Dear Messrs Cowperthwaite and Dyer,

We, the undersigned, are a group of leading objectors at this Examination. You have led the examination process with a genuinely inquisitorial approach, however as things stand, we are concerned that any report to the Secretary of State will lack the necessary evidential base. Information which is clearly important and relevant, and which is needed to inform your recommendations to the Secretary of State on the balance between the adverse impacts and the benefits of this scheme, has not been made available to this Examination by the Applicant. It has therefore not been scrutinised and challenged to ensure that it is robust. **We are, therefore, writing to ask you to take action to ensure the integrity and soundness of this Examination.**

There are three matters of concern: the traffic model, the omission of a WebTAG compliant Transport Appraisal, and the carbon assessment. We look at these in turn.

Figure 3-7 – Fixed Cost Function (FCF) area

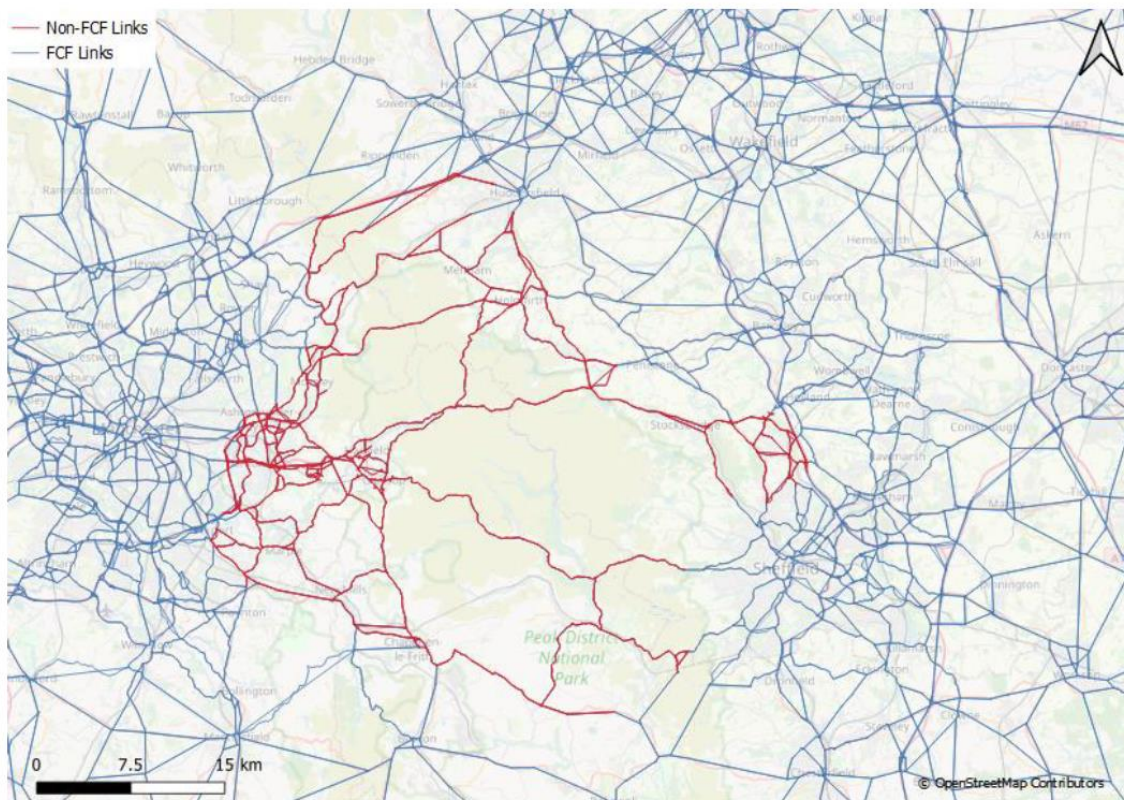
7. The model does not represent the impacts of the scheme on transport networks in Greater Manchester. The scheme has been treated as an isolated bypass with limited access to Greater Manchester, with a fixed cost function and a masking approach¹ applied to Greater Manchester including to the majority of Oldham, 20% of Tameside and 40% of Stockport boroughs². This is despite the majority of journeys being within Greater Manchester.

² See figure submitted to D10 of fixed cost function area in REP2-090 Figure 3-7 pdf page 289/790 with the three borough boundaries overlain.
